Office of
Environment
& Heritage

Our reference: DOC15/181019
Contact Marnie Stewart, 9995 6868

I refer to your letter received by the Office of Environment and Heritage (OEH) on 27 May 2015 requesting comments on the Response to Submissions (RtS) for the Moorebank Intermodal Terminal at Moorebank Avenue, Moorebank (SSD-5066) during the public exhibition.

Attachment 1: OEH comments on the Response to Submissions for the Moorebank Intermodal Terminal Facility SSD 5066 during public exhibition

4.2.2 Casula Offset area

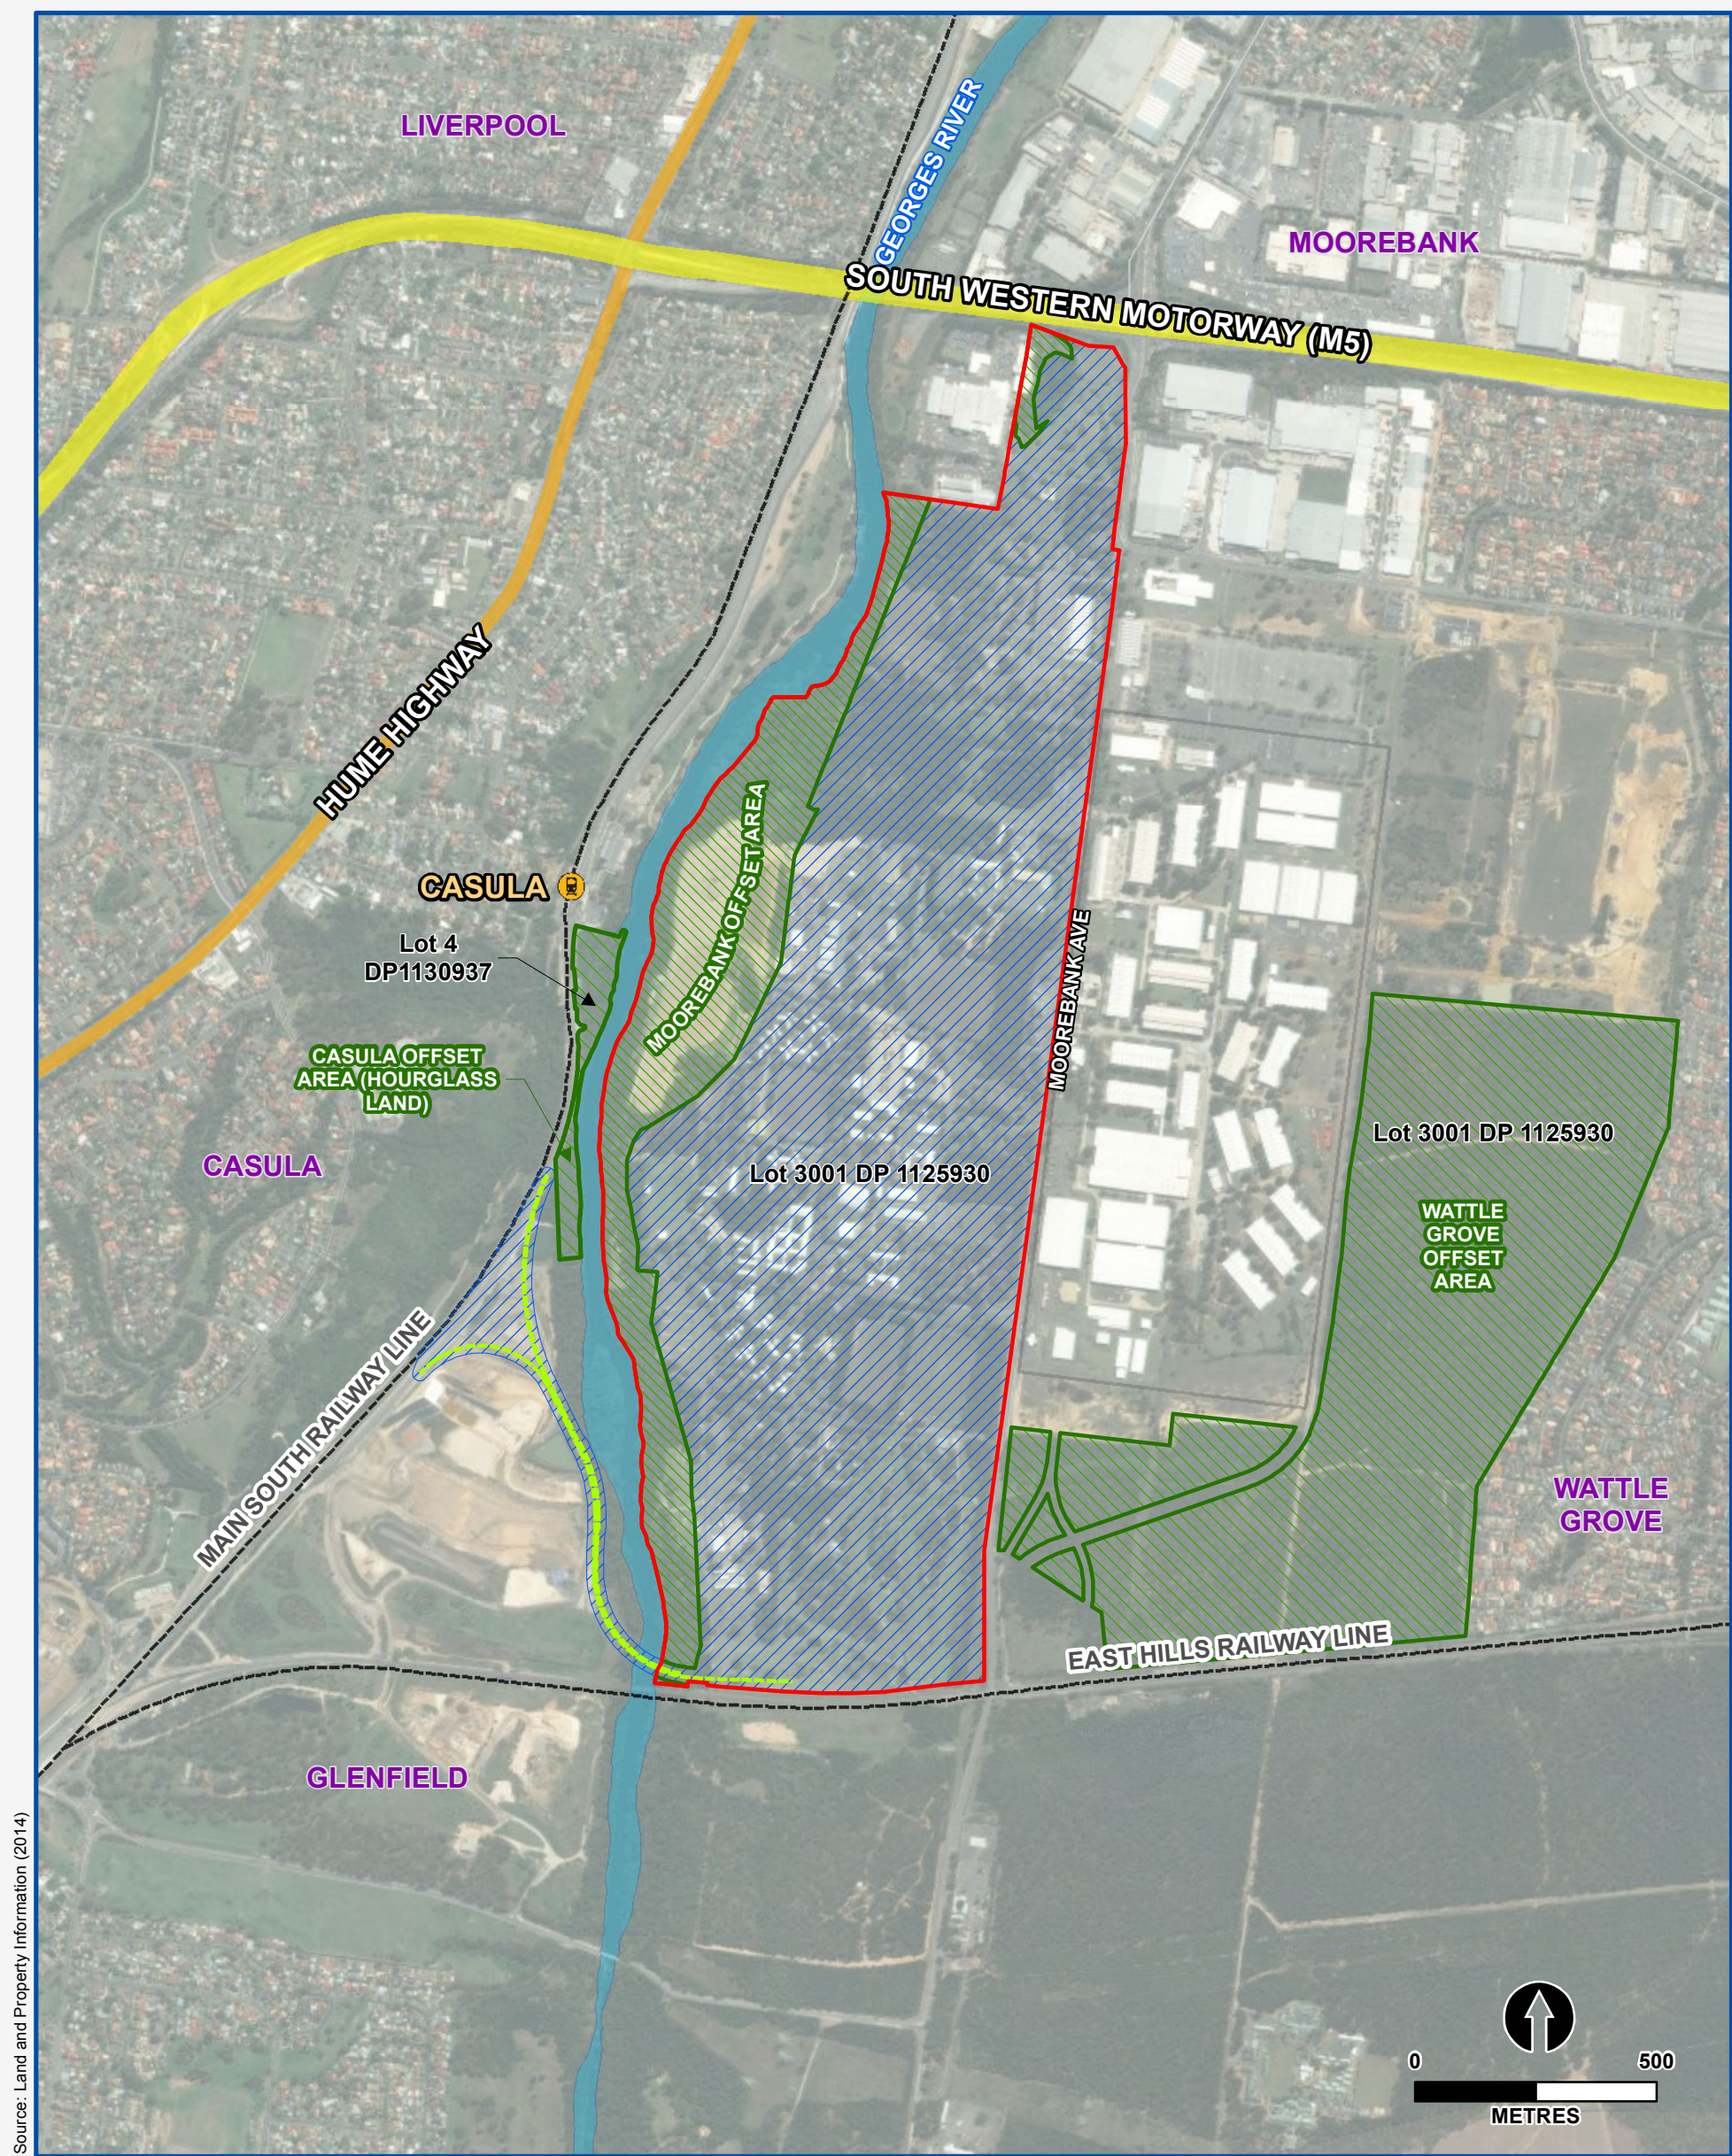
Sections 4.2.1 and 4.2.2 of the BOS indicate that it is still proposed to rezone the Moorebank and Casula conservation areas as E3 Environmental Management. As previously advised, the biodiversity offset areas should be afforded the highest level of zoning protection. OEH continues to recommend the use of E2 Environmental Conservation as this zone contains the most appropriate objectives and permitted uses for the biodiversity offset areas, and reflects the intent of the land for conservation purposes.

Figure 13.11 Moorebank offset area - Conservation area and Casula offset area (hourglass land) - vegetation communities

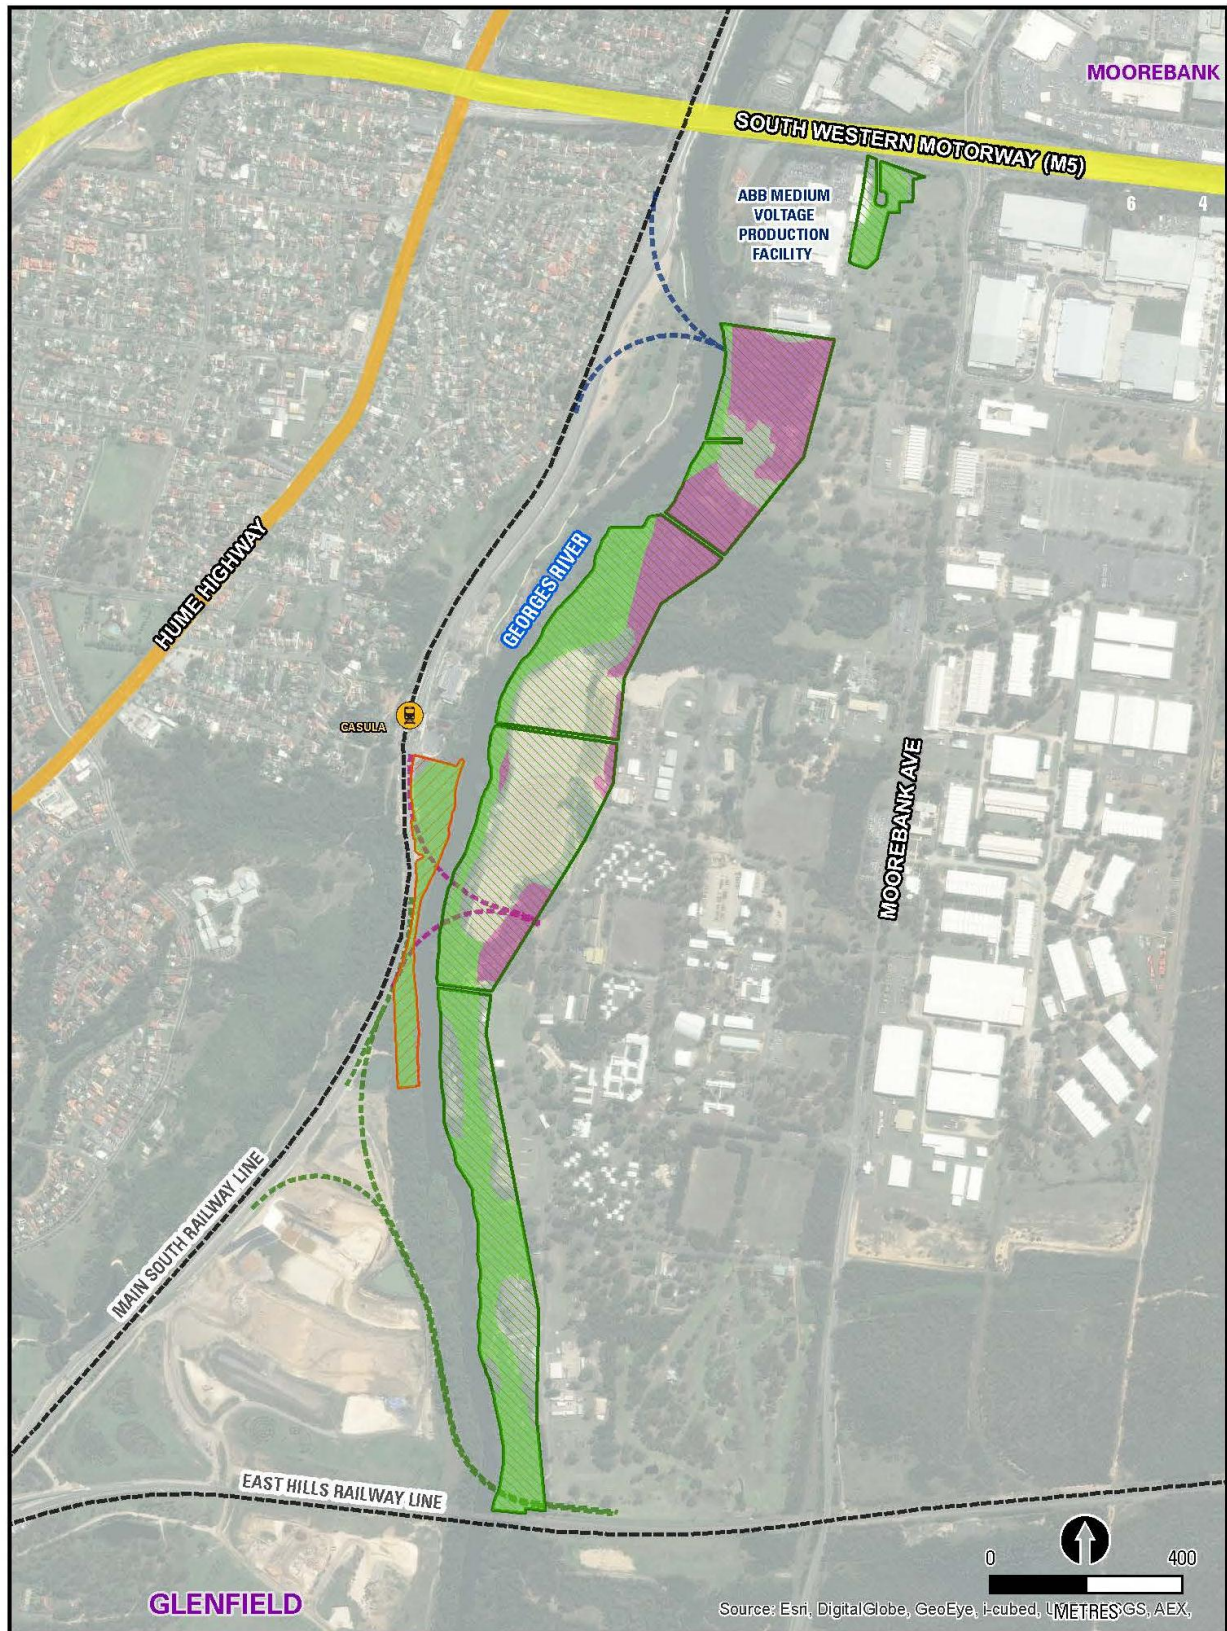
OEH notes that the Biodiversity Offset Strategy (BOS) does not commit to providing offsets via a biobanking agreement for the Moorebank and Casula offsets. As stated in OEH's previous comments dated 18 March 2015, the NSW Biodiversity Offsets Policy for Major Projects 2014 requires a biobanking agreement be used to secure the offset site, unless there are no credits on the market, or other criteria under Principle 5 are met. OEH remains of the view that the applicant needs to make a stronger commitment to biobanking as the conservation mechanism protecting the offset.
